# **WATERLOO METRO QUARTER CENTRAL PRECINCT**

## **SSD-10439 - RESPONSE TO SUBMISSIONS DESIGN STATEMENT**

**DPIE RFI - 13/04/2021**

WEST APARTMENT

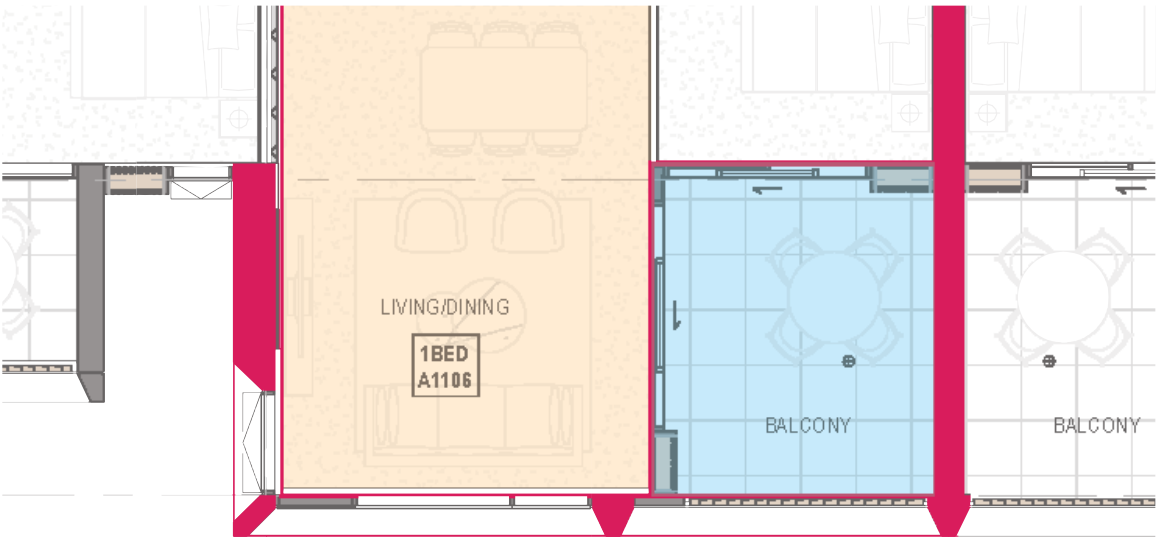
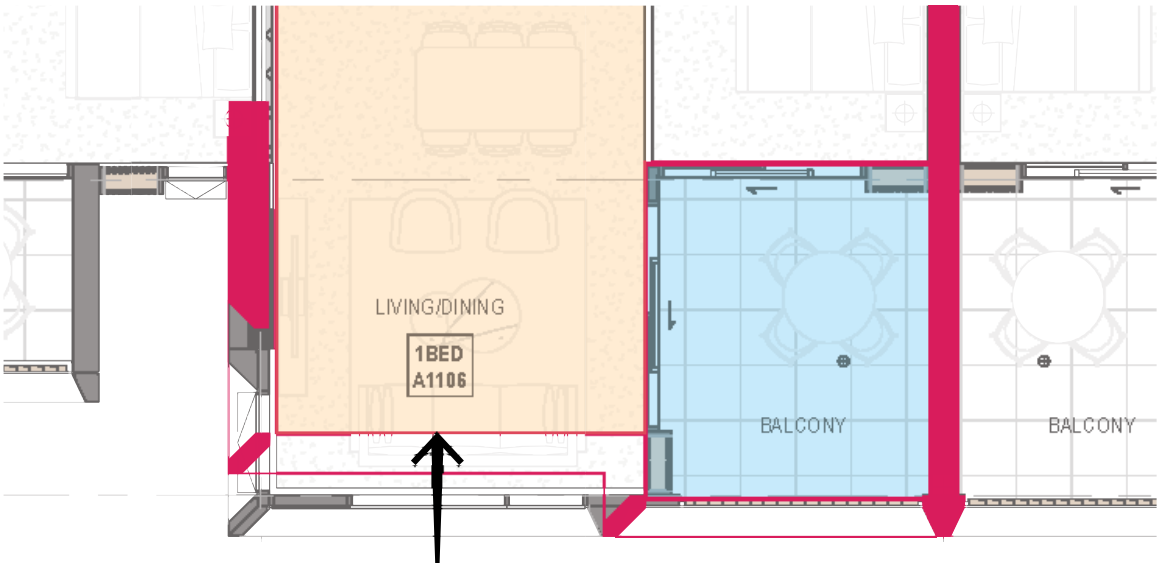
- Shifting the west 1 bedroom living room facade east to allow north facing frontage to the adjacent POS to receive solar access at 1:00pm mid winter.
- Similarly, the west facade change is reflected in the vertical stack from level 3 to rooftop terrace to provide consistency in built form.

The west facade of the 1 bedroom apartment living room to shift east 700mm to provide north facing frontage to the adjacent POS.

With the above design change, both the living room and POS of the 1 bedroom apartments between level 6 and level 19 achieve 1 sqm of solar access for 1 hour and 50mins between 1:10pm and 3:00pm mid winter. The living room and POS recieve solar access for a minimum of 2 hours between 9:00am and 3:00pm but less than 1sqm for 10 mins.

HIGHRISE EAST/WEST APARTMENT

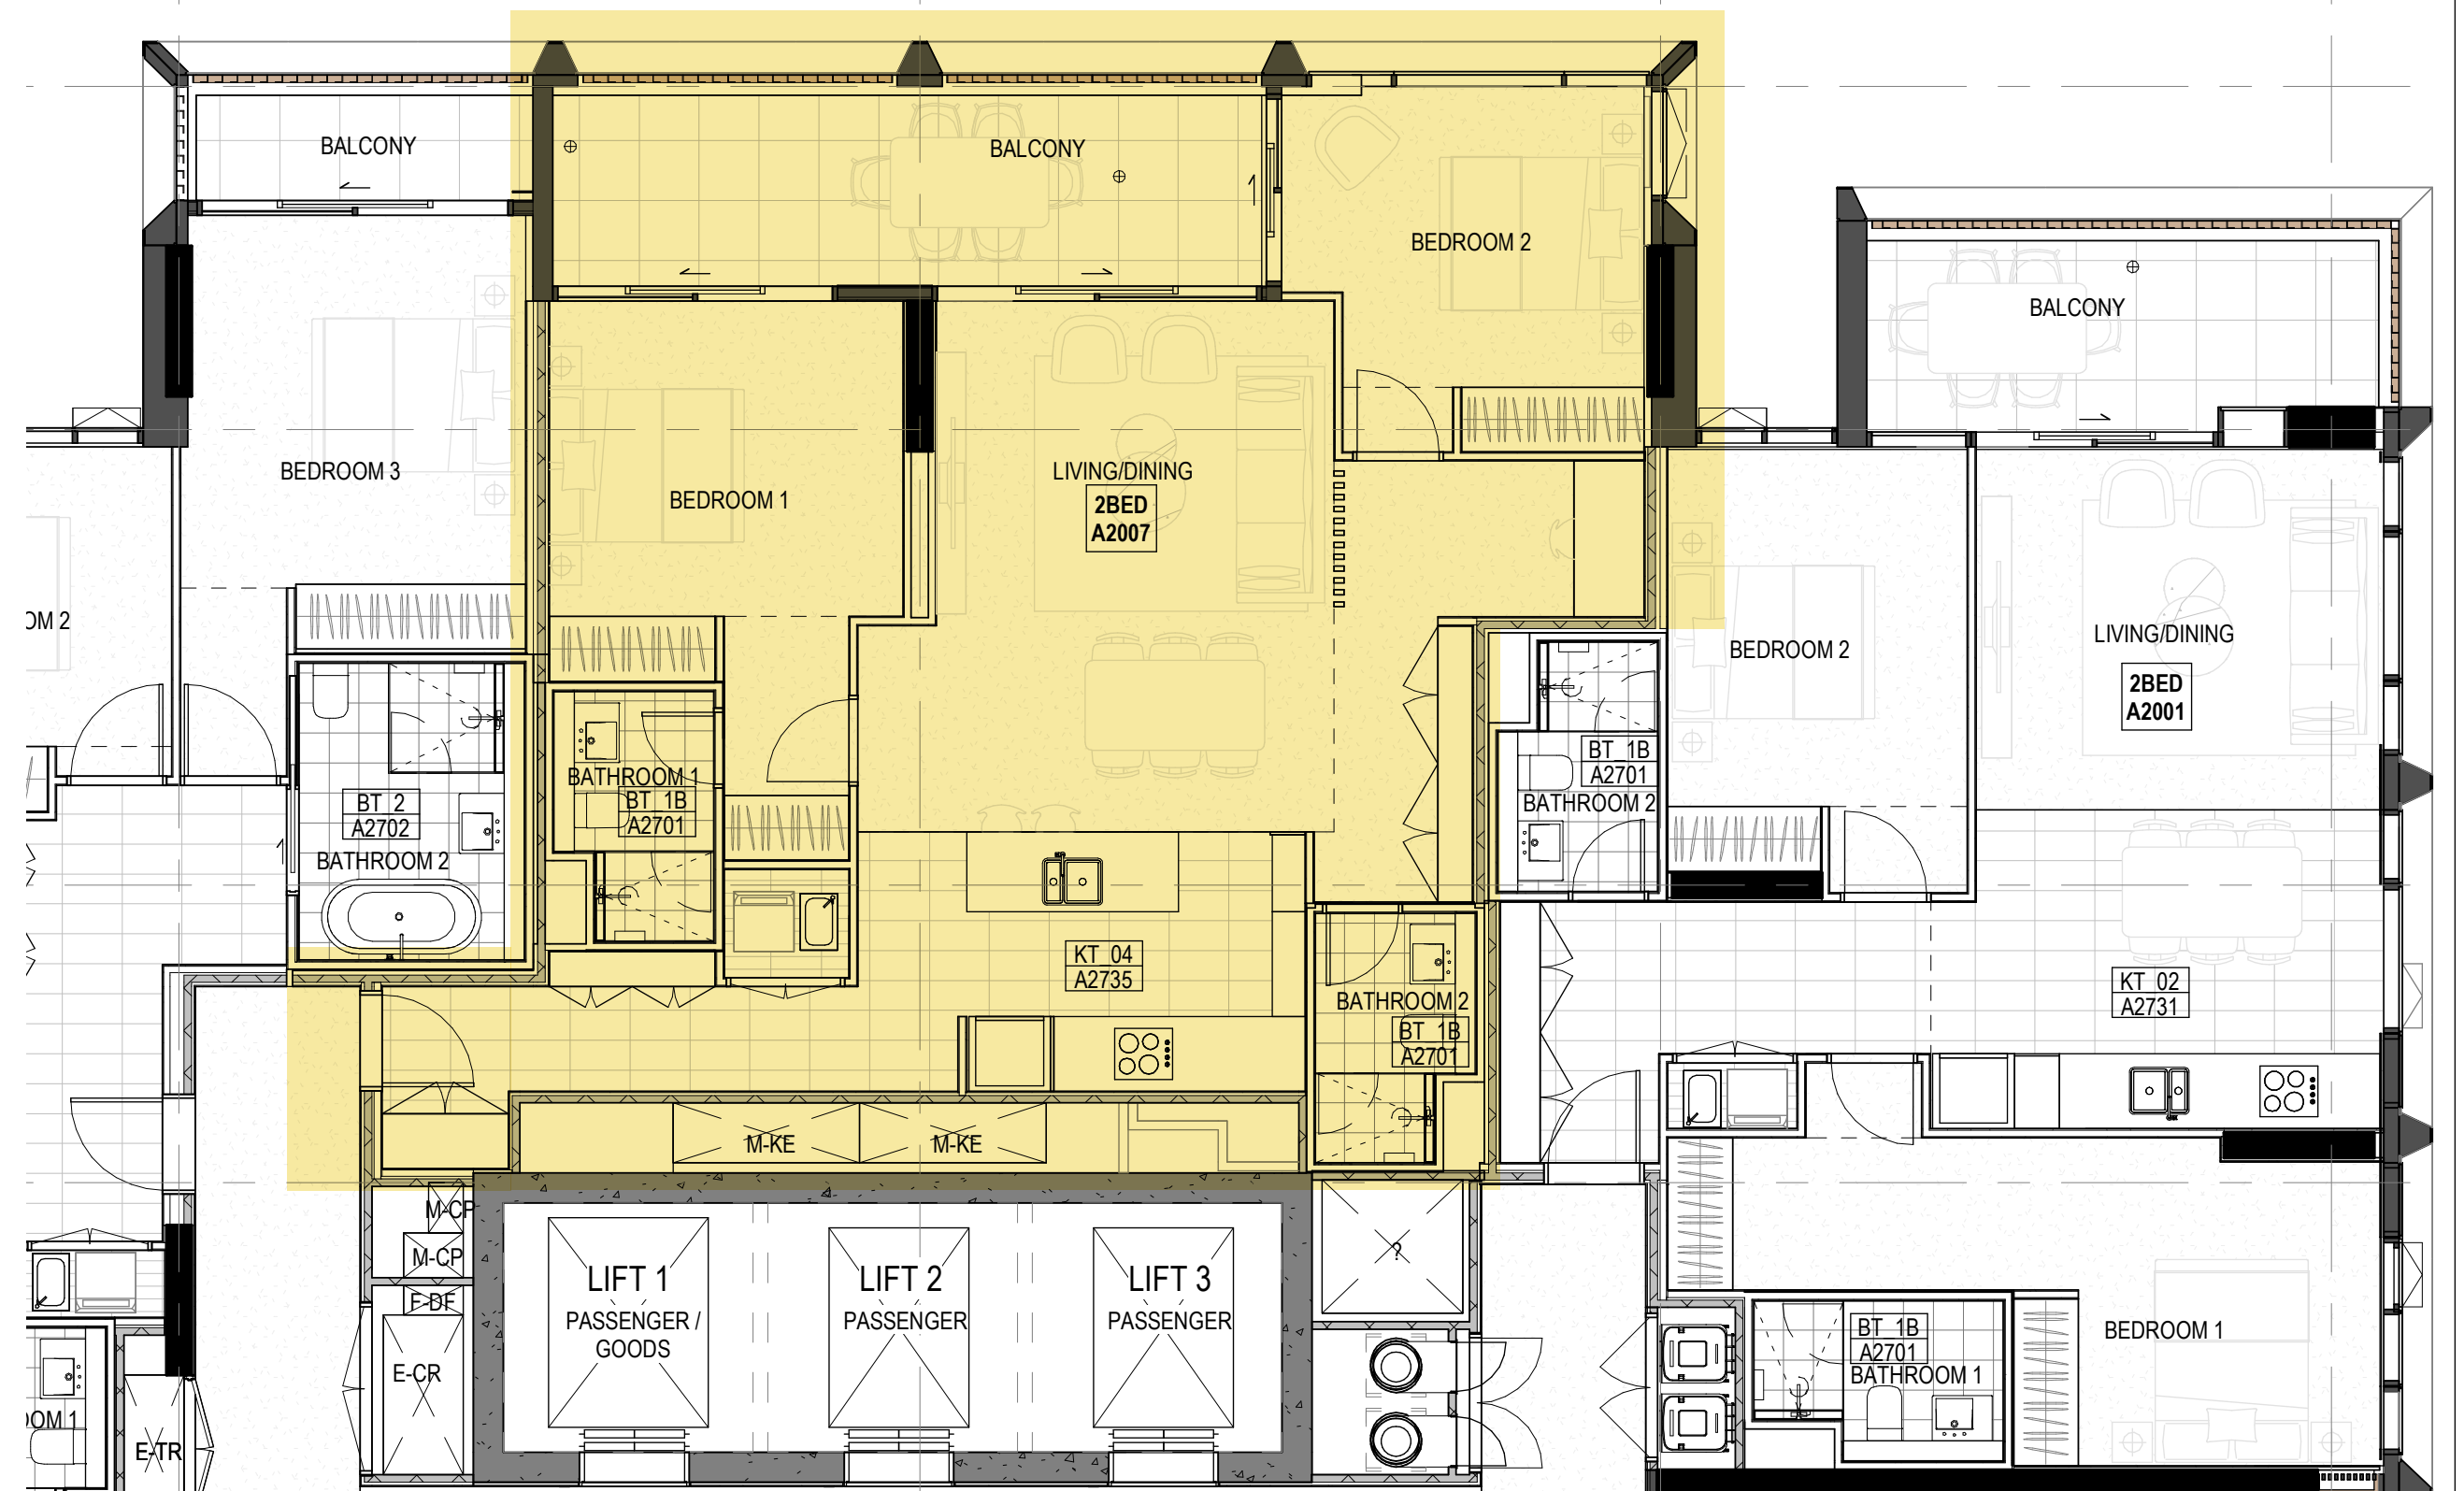
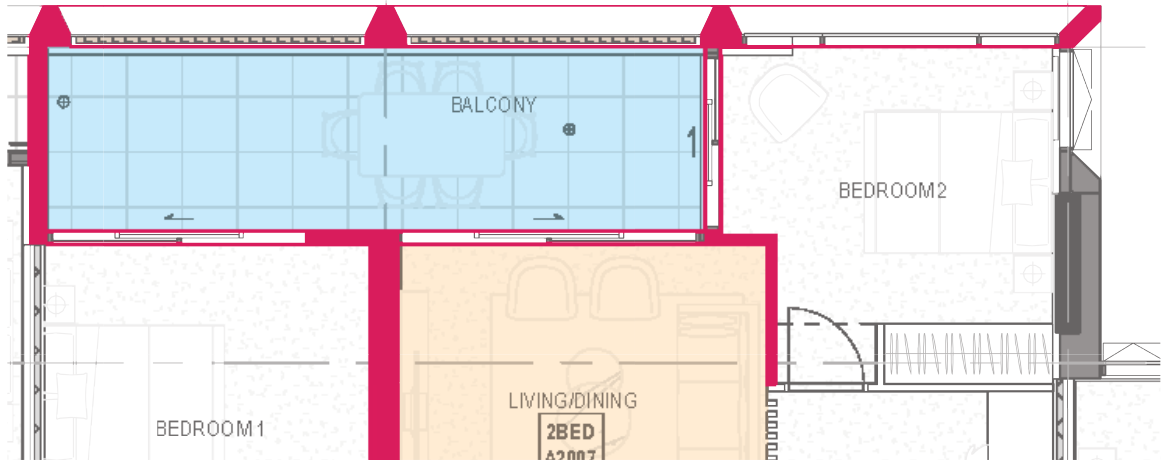
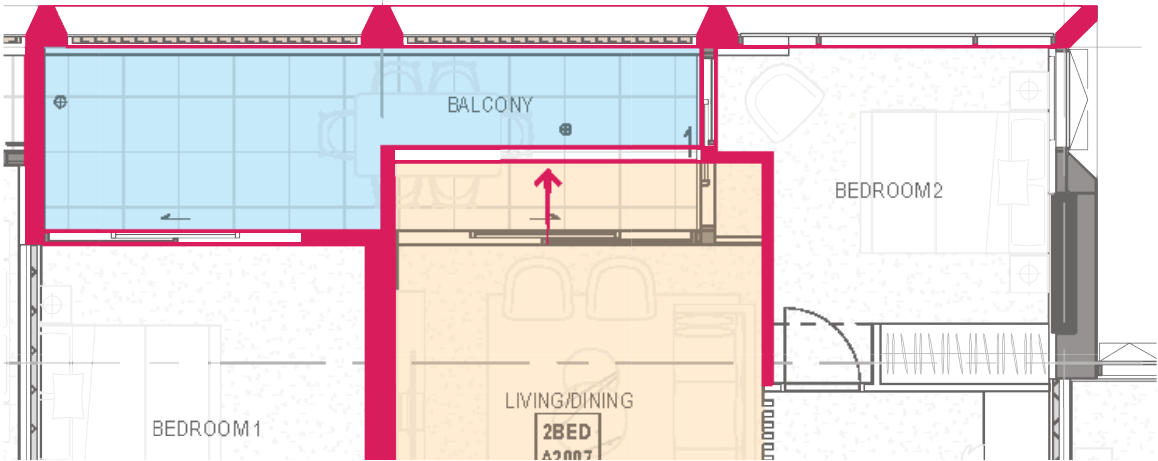
- Shifting the east captured 2 bedroom apartment living room glazing further east to achieve 2 hours of solar access to living room between 9:00am and 3:00pm mid winter.
- Similarly, this change is reflected in the mirrored west apartments to provide consistency in built form.

The living room glazing is shifted east by 1m while maintaining the minimum requirement for depth and size of the POS in accordance to ADG.

With the above design change, both the living room and POS of the captured 2 bedroom apartments on level 20 and 21 receive 1sqm of solar access for 2 hours between 9:00am and 11:00am mid winter.

HIGHRISE WEST APARTMENT

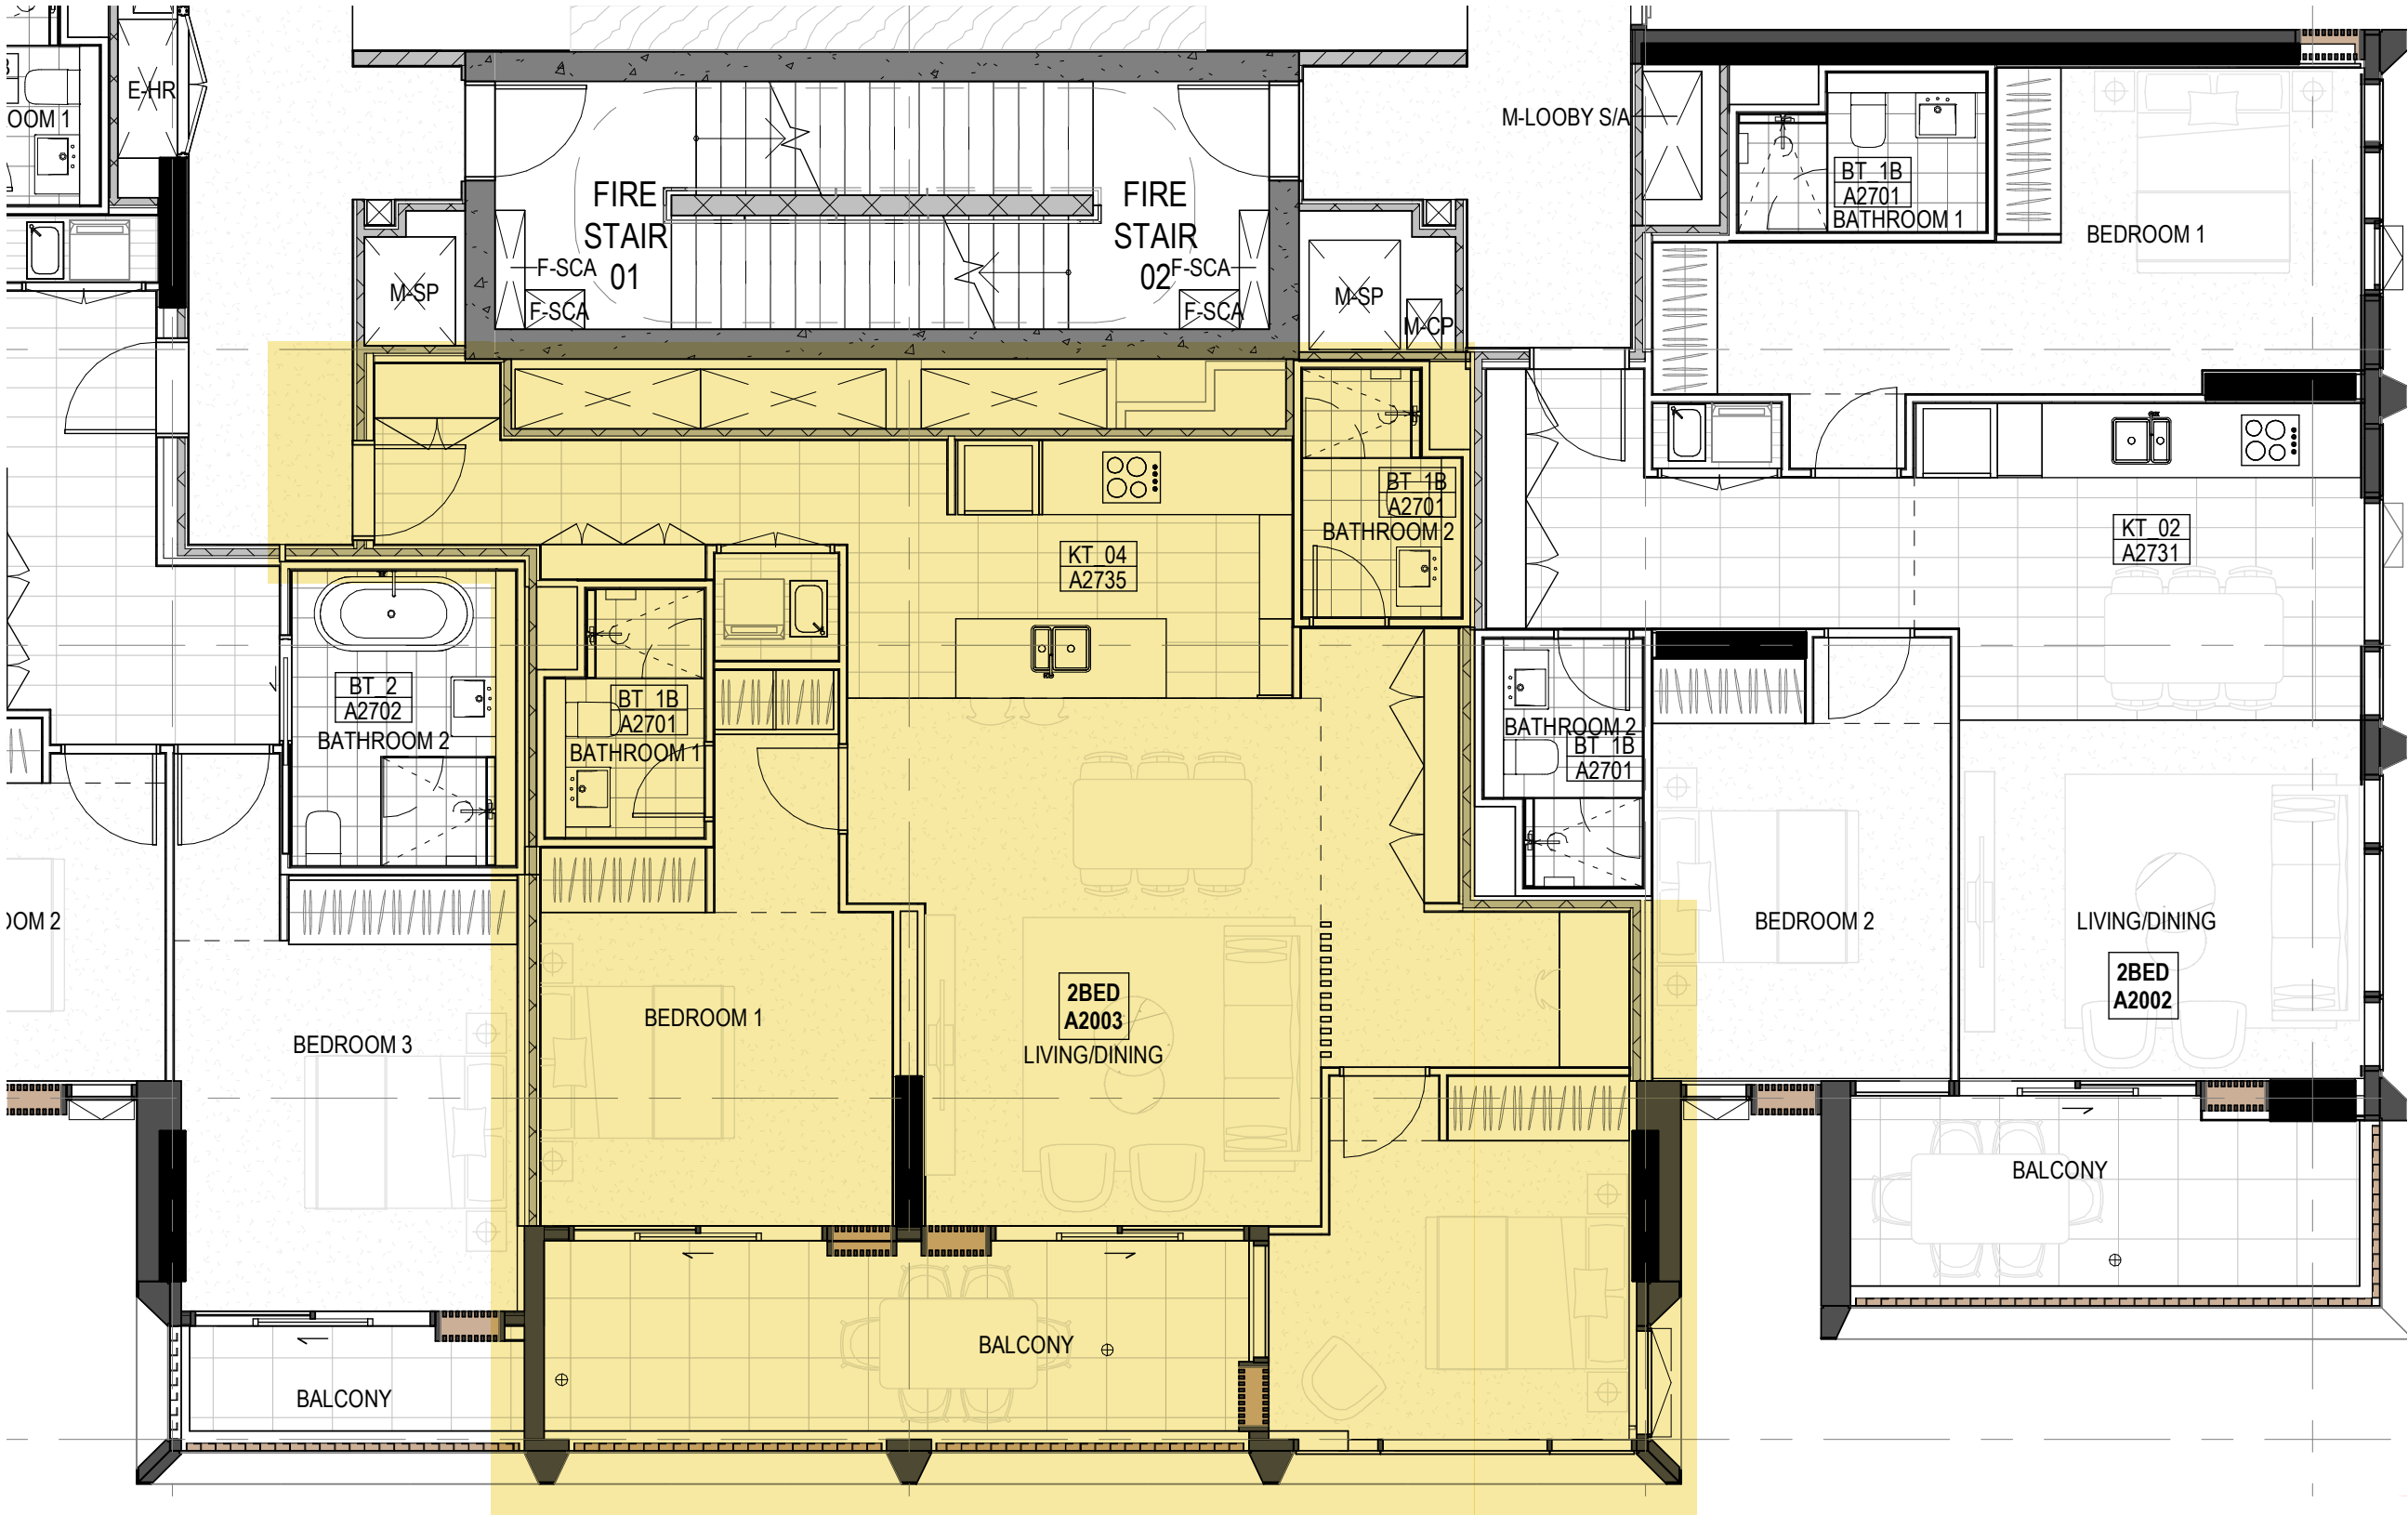
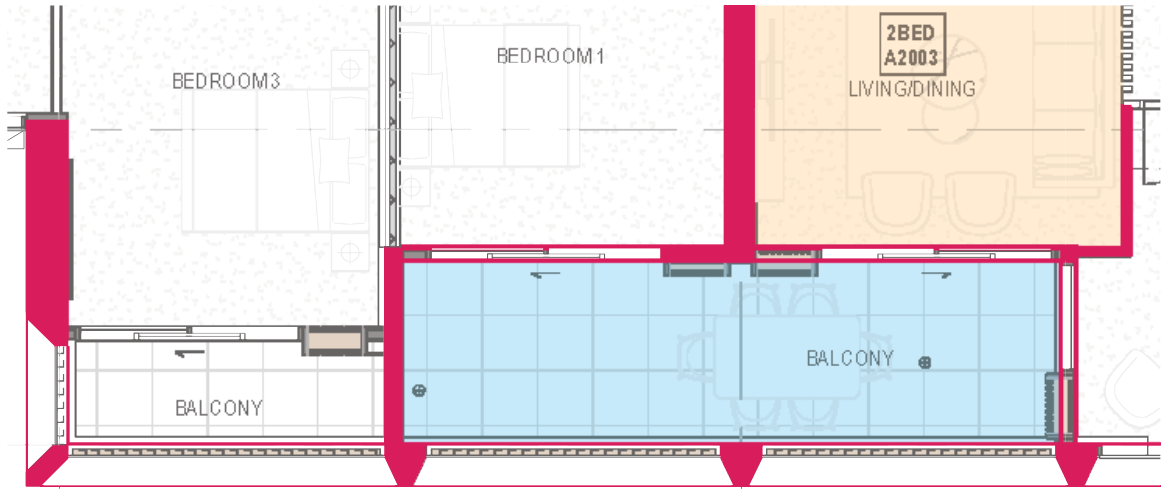
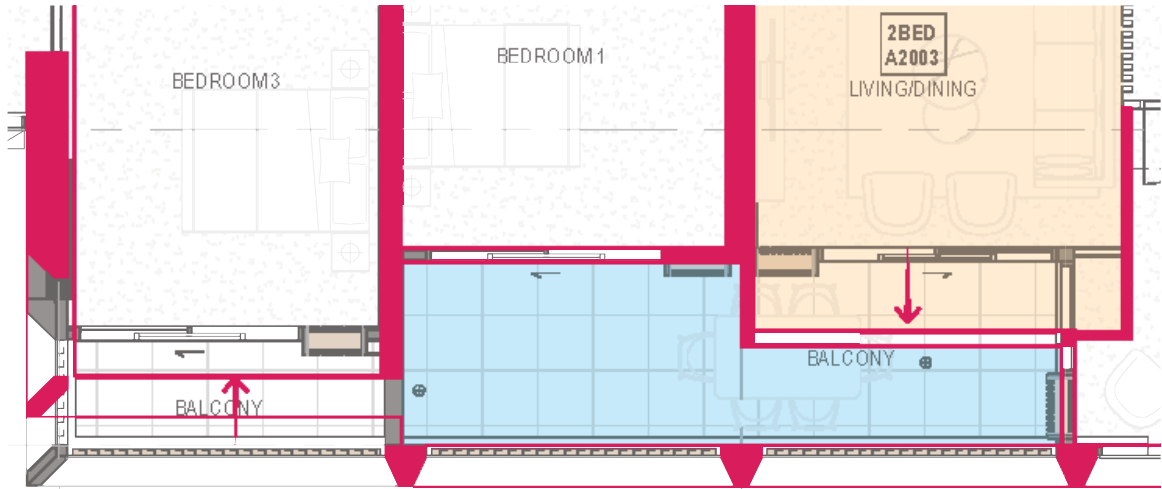
Opportunity to improve solar access to living room and POS by adopting the same change as the east high rise apartments.

The living room glazing is shifted east by 1m while maintaining the minimum requirement for depth and size of the POS in accordance to ADG. The bedroom of adjacent apartment to shift east 700mm to allow POS to have north facing frontage.

With the above design change, the POS on level 20 and 21 receives 1 hour and 50mins of 1sqm direct solar between 1:10pm and 3:00pm while the living rooms receive 50 mins of direct solar between 2:10pm and 3:00pm.
